6 November 2013

Re: Application No: MP07_0158 MOD 3 - Objection to Modification Request for the University of Sydney Abercrombie Precinct Redevelopment – Proposed Student Housing Building

Sheridan Planning (**SP**) is acting on behalf of Mandelbaum House, a residential college which adjoins the site of the proposed Student Housing Building on the Abercrombie Precinct at the southern end of the Darlington Campus, University of Sydney. **SP** has been engaged to review the above modification application and prepare a submission to the Department on behalf of Mandelbaum House.

02 ELEVATION SOUTH (ABERCROMBIE STREET)
SCALE 1:200

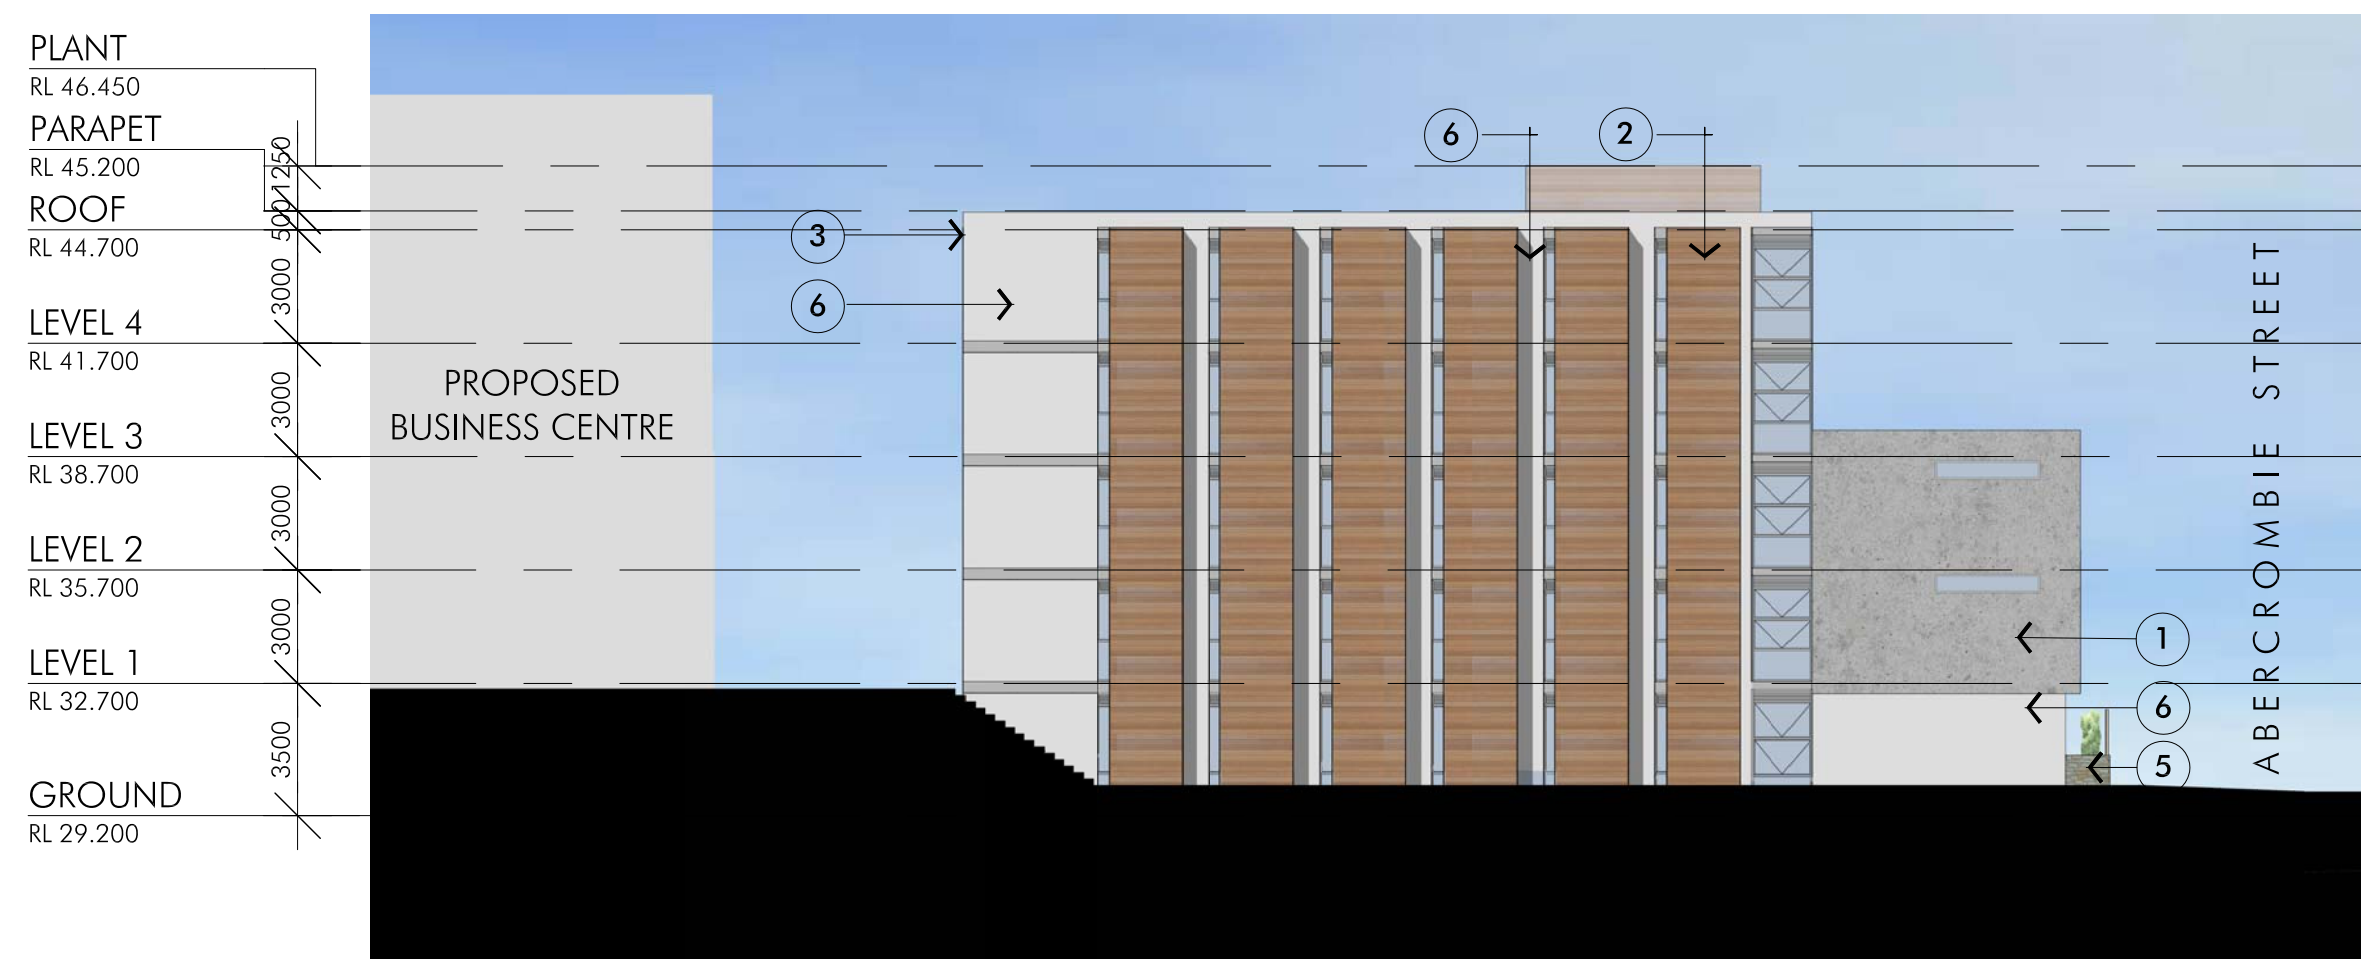
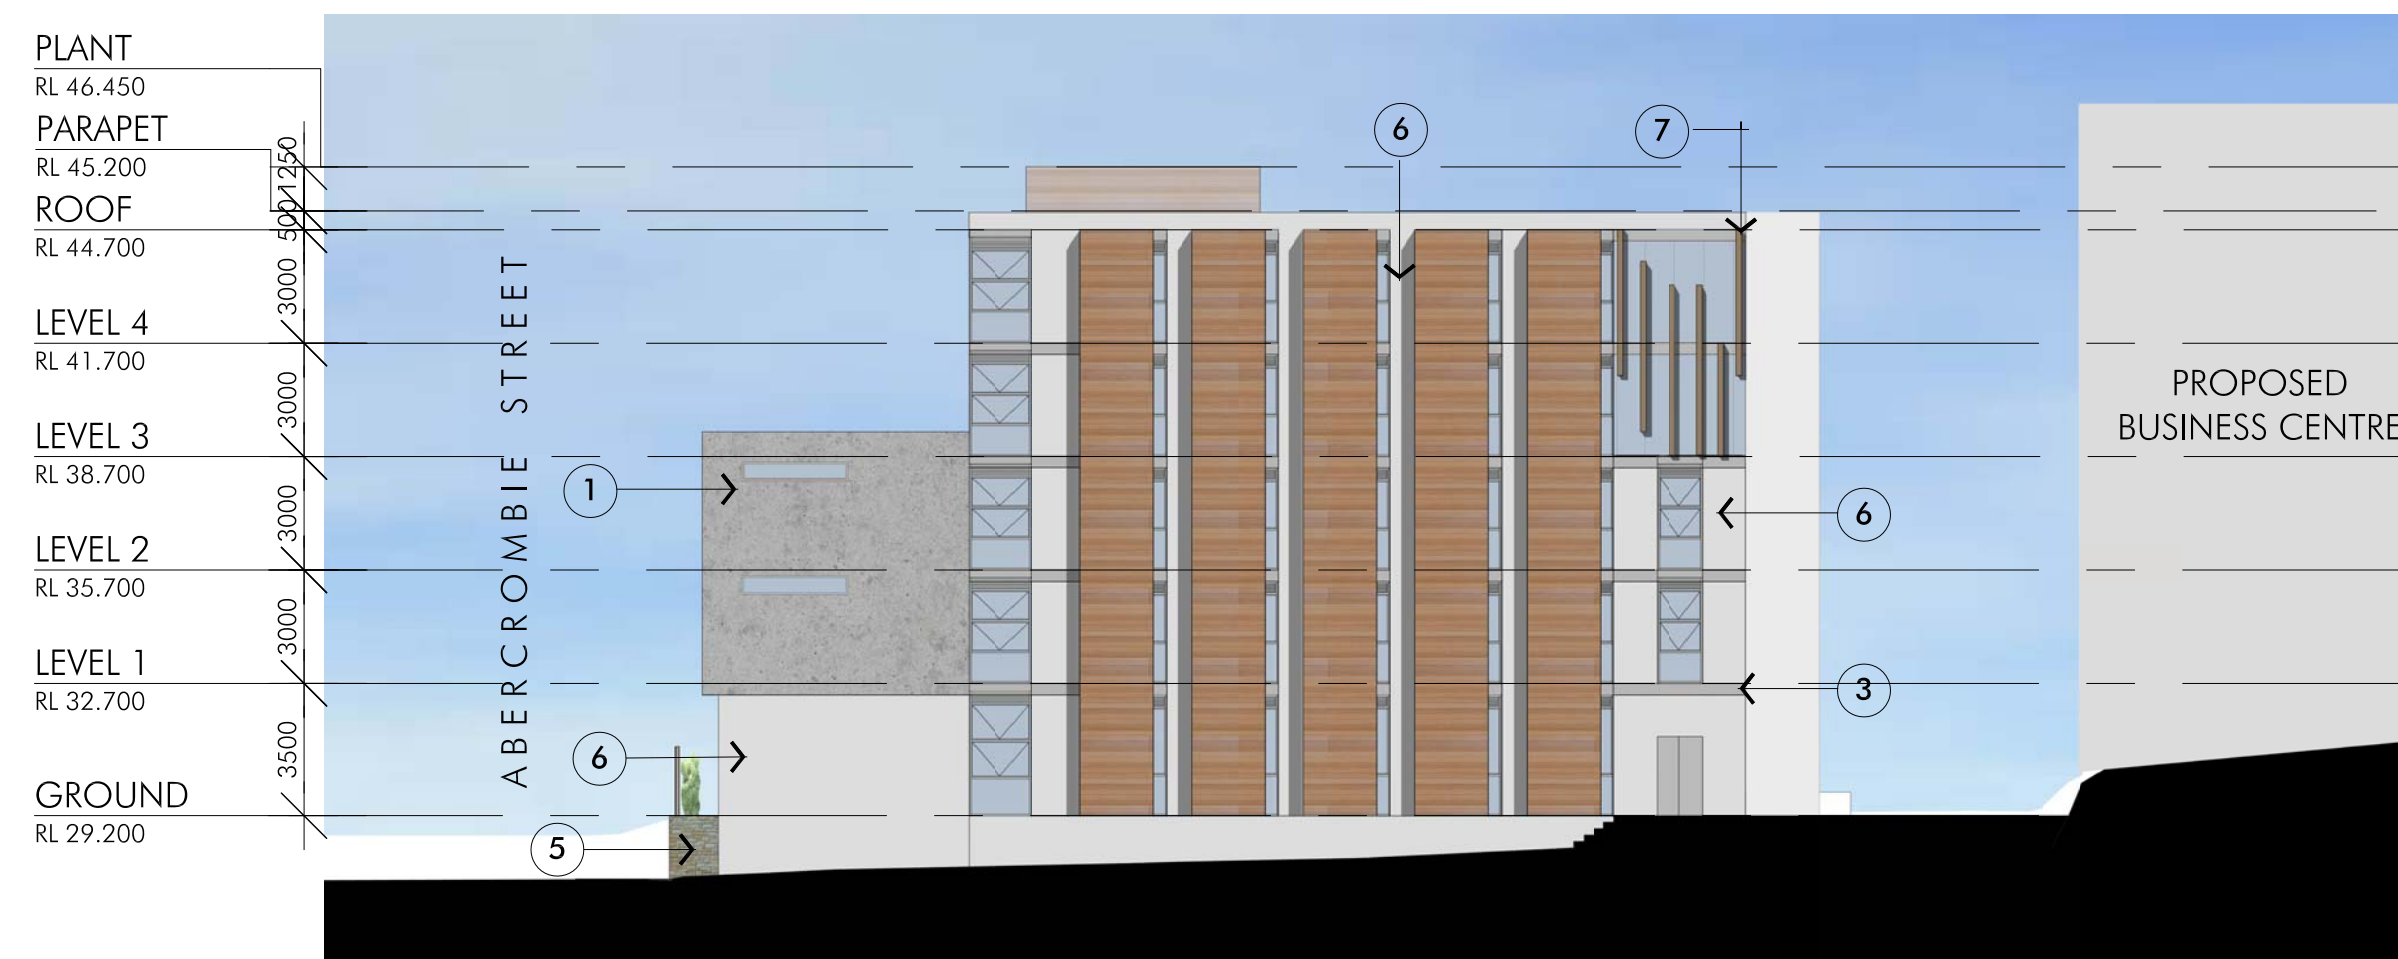
On the other hand, the proposed Student Housing Building (see **Figure 1** below), located directly to the west of Mandelbaum House, is proposed at 4-5 storeys in height along Abercrombie Street. The fifth storey has a minimal setback from the four levels below, which does little to disguise the bulk of the building along the Abercrombie Street frontage.

The Student Housing Building which adjoins Mandelbaum House is bulky and out of scale with the character established by the existing buildings in Abercrombie Street, including the relatively recently built Mandelbaum House. The excessive scale and bulk of this proposed building will not only have significant impacts on the streetscape, but will have an adverse impact in terms of privacy, overshadowing and visual impact on Mandelbaum House (See **Point 3** below). As Mandelbaum House and other surrounding residential and commercial buildings, have had to comply with strict height, streetscape and heritage planning controls the proposed University Student Accommodation building should also comply with these criteria.

- The building should be reduced in height and scale so that it is consistent in height with Mandelbaum House and conforms to the established 2-3 storey characteristic height of buildings along Abercrombie Street.
